Application No: EP/157/21/PL
Site Address: 4 Beechlands Close and East of 18 Beechlands Court East Preston BN16 1JZ
Description of works: Erection of 1 No 2 bed, 3 person dwelling (resubmission following EP/69/21/PL).
This site is in CIL Zone 4 and is CIL liable as new dwelling.

Thank you for your internet representation made on 6th January 2022 which has been recorded as an objection with the comments as follows:

GROUND FLOOR

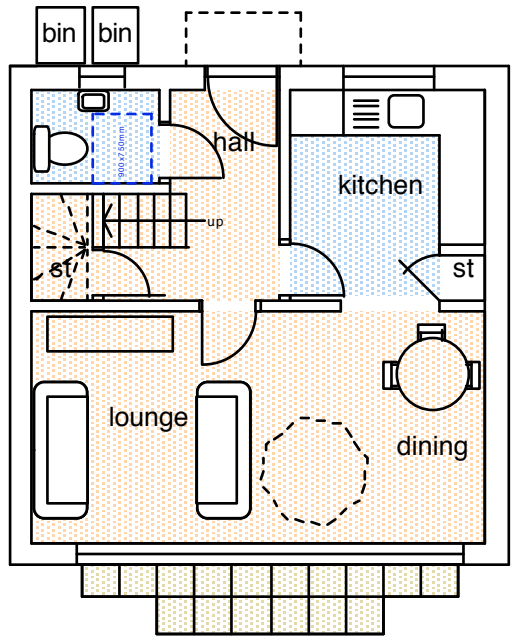
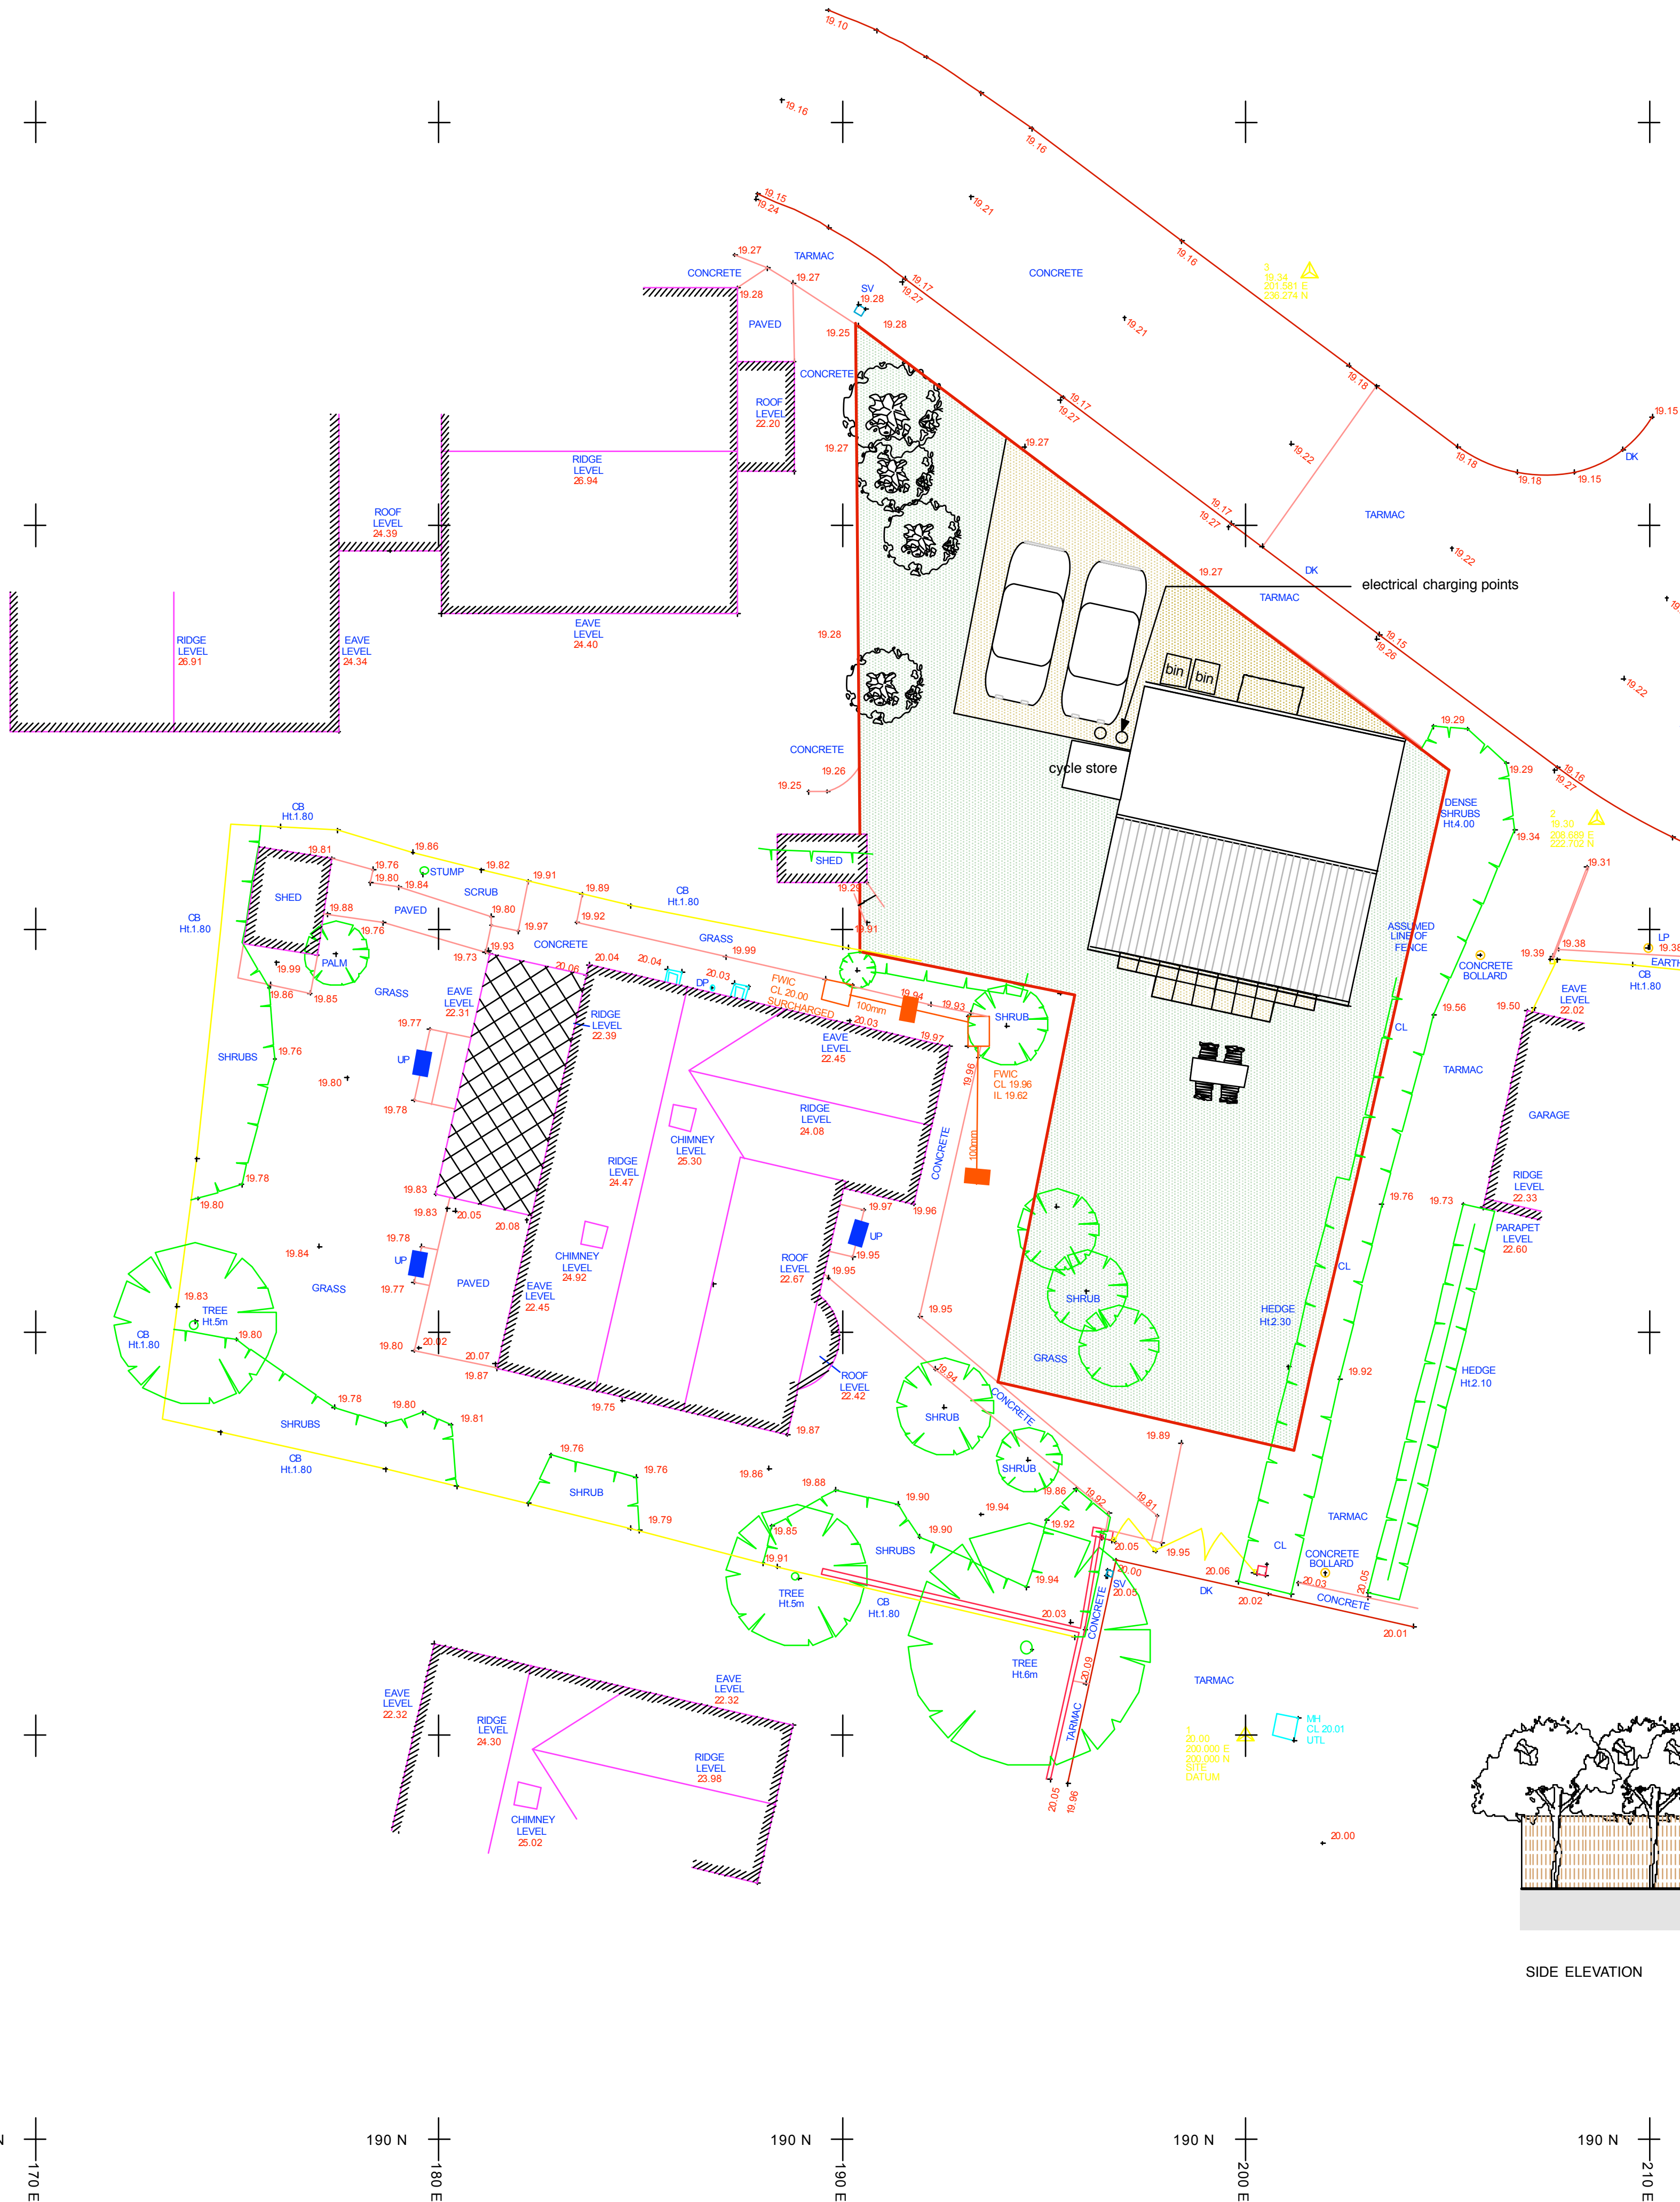
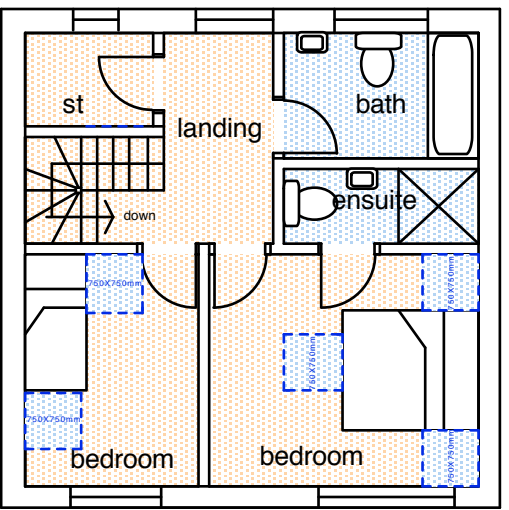
The property would still be set very far forward on the plot. Extending the garden by taking some of the garden of 4 Beechlands Close and will, we believe, result in the front of that property having little space between it and the fence of the proposed property. This may result in 4 Beechlands Close being the property with a lack of distance between it and site boundaries and feeling cramped.

Members still believe the proposed property would be out-of-keeping with the streetscene and the general spatial character of the area. Directly opposite the plot, the flats have attractive front gardens which enhance the area. A 3 person dwelling could easily result in three vehicles at the property; as only two parking spaces have been provided this will result in an increase in on-street parking in an area which already sees a heavy demand for on-street parking.

FRONT ELEVATION

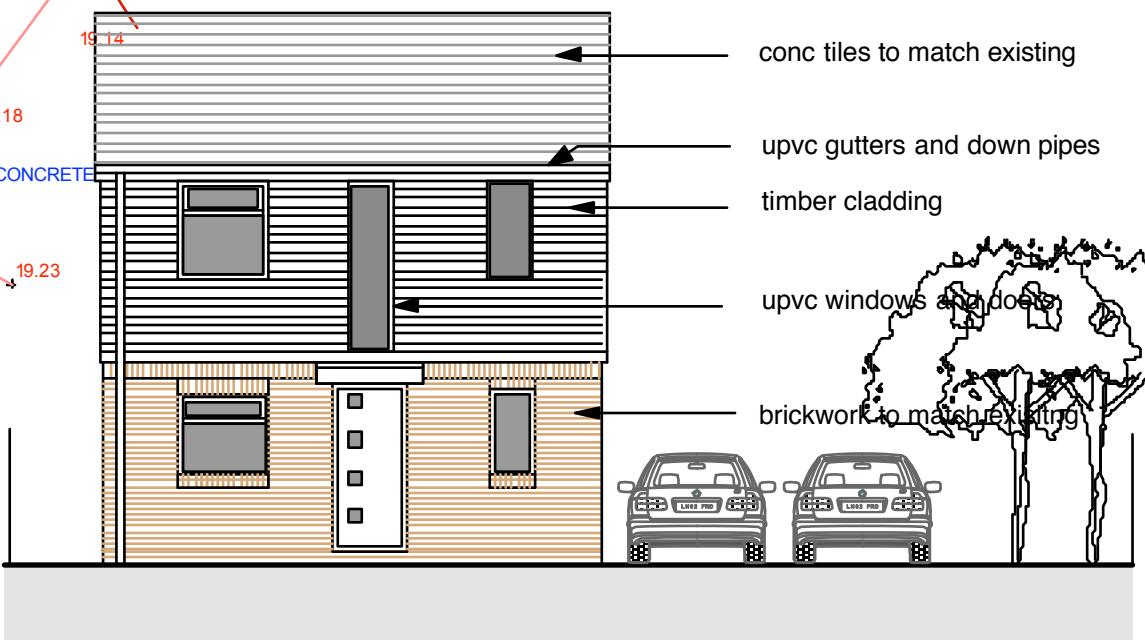
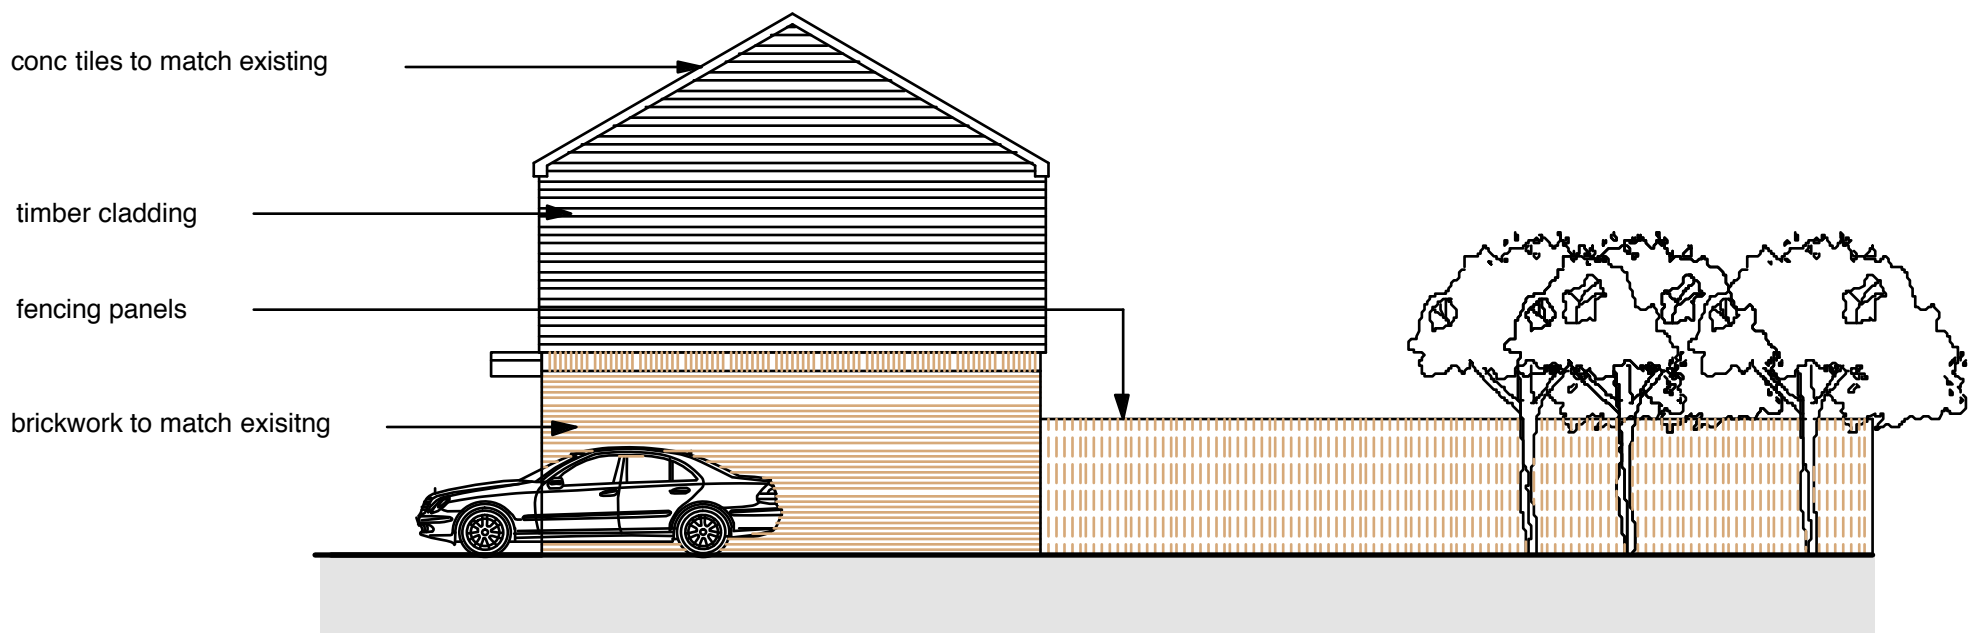
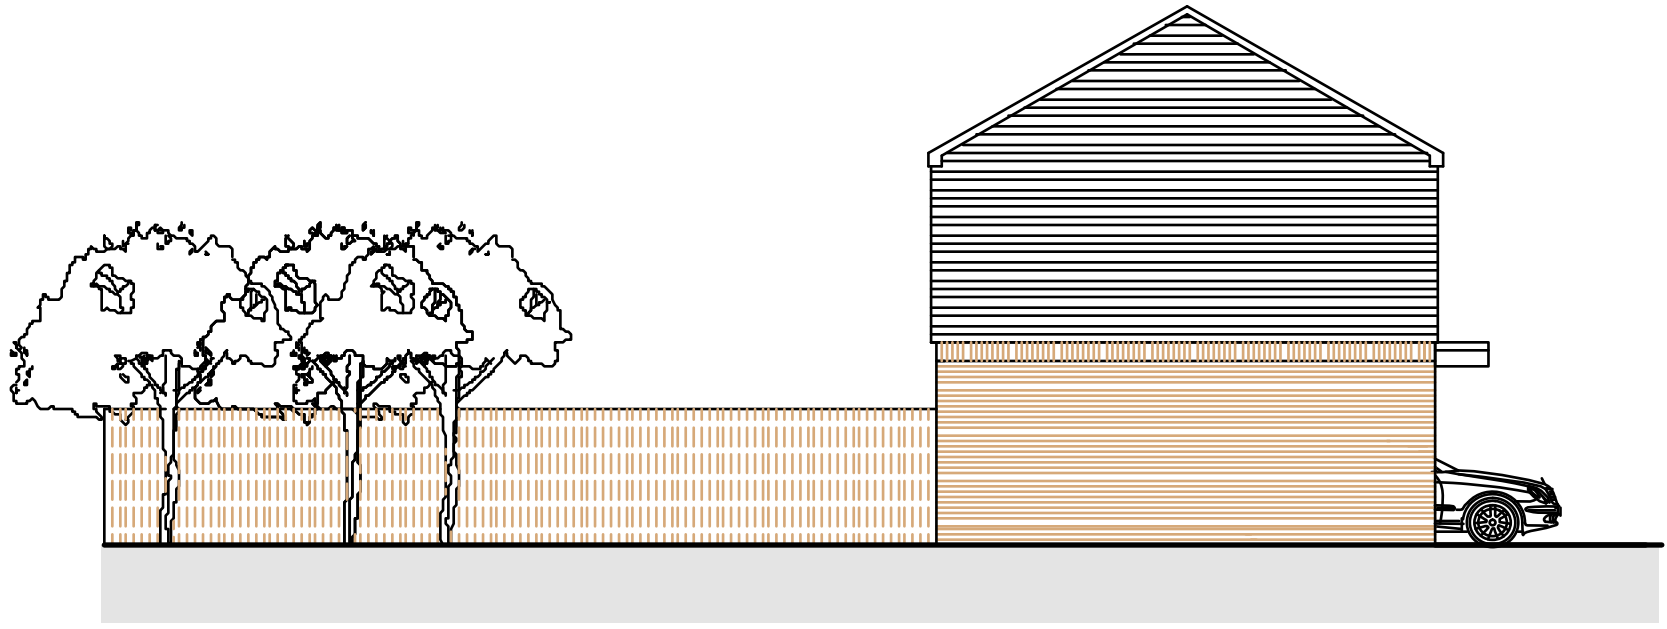
The site is in Character Area Two of the East Preston Neighbourhood Plan. The proposed property includes a first floor and a high roofline is contrary to Policy 3i which states maintain a consistent low building height, with no development proposal of more than 1.5 storeys.
